DEVELOPMENT REVIEW BOARD--SPEED MEMO

DRB CASE NO/PROJECT NO: 1003748

Project Number: 1003748
Application Number: 04DRB-01660

RE: Tracts 8E & 9E, Lands of Hollingsworth/sketch

18 OCTOBER 2004
2 2

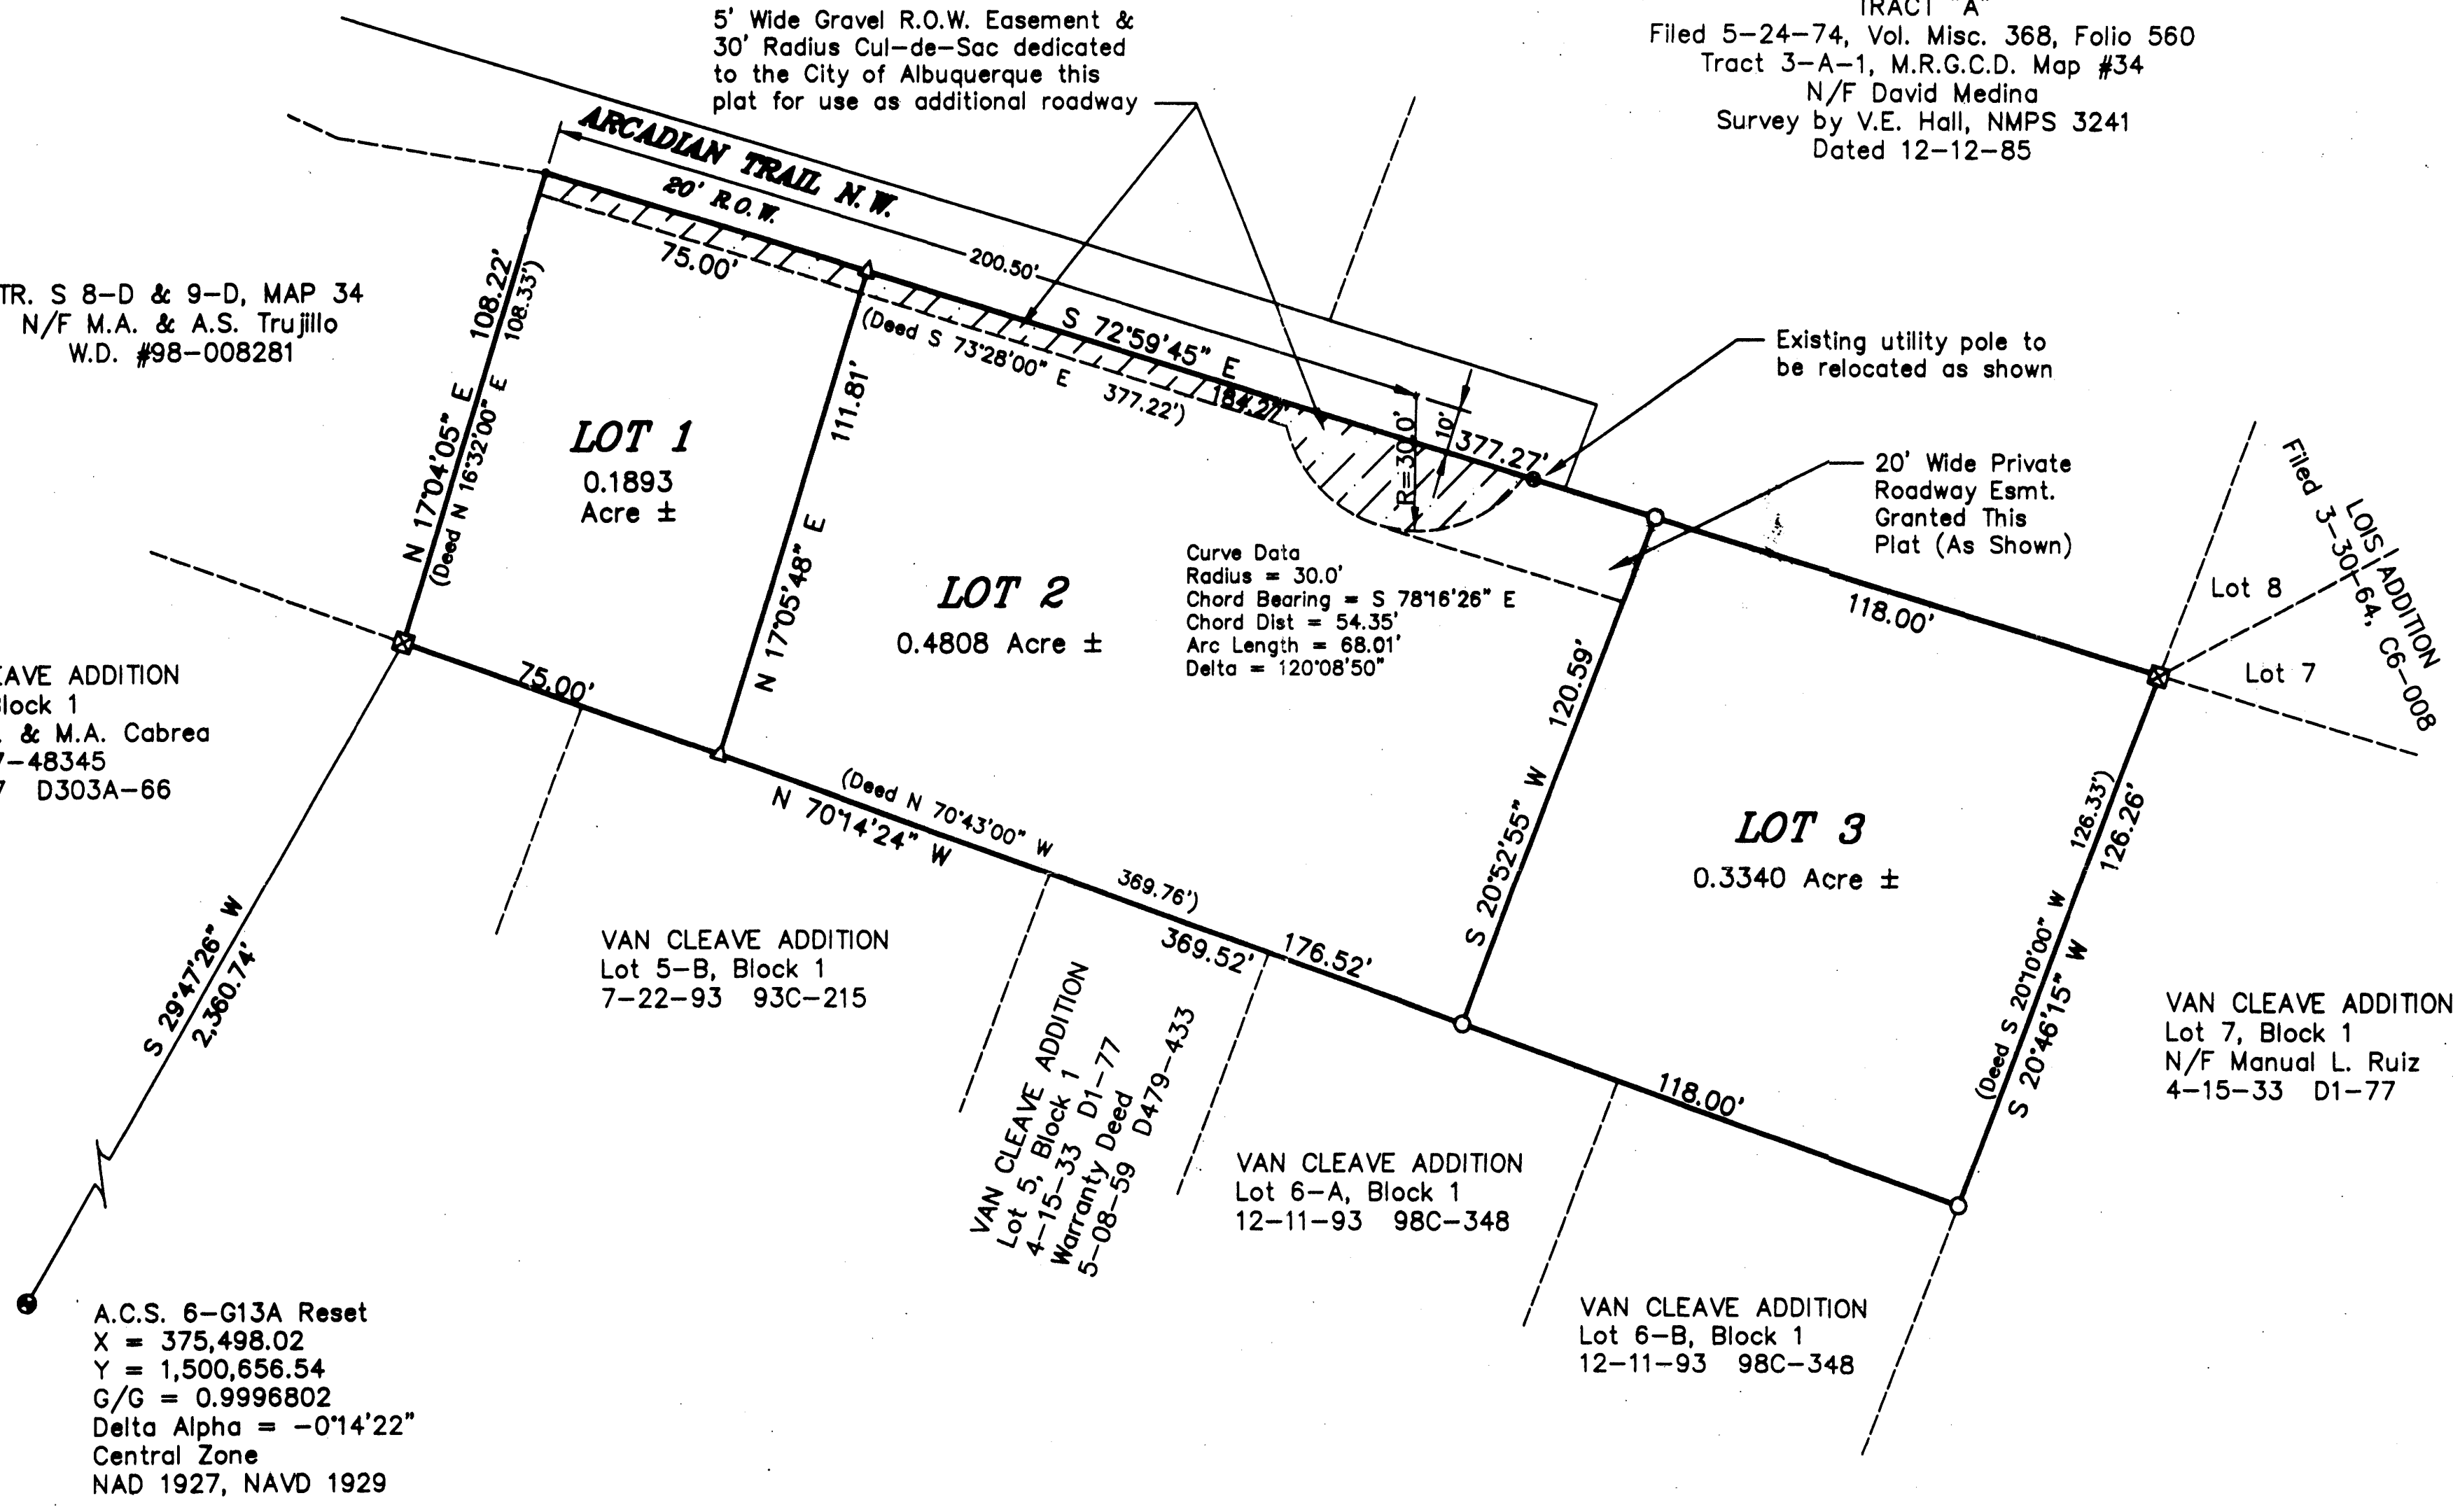
3) Plat does not show a public sewer easement
for the exist SAS on north side of your
property.

RA2 zoning requires a minimum of 10,890 square feet for each lot and a minimum lot width of 75 feet. Lot 1 does not have the required square footage. Perhaps Lot 2 could contribute enough square footage. Because a sketch of existing buildings was not provided, a determination could not be made if this would be possible.

25' rear yard setback required
Existing house on Lot 2
faces Lot 3
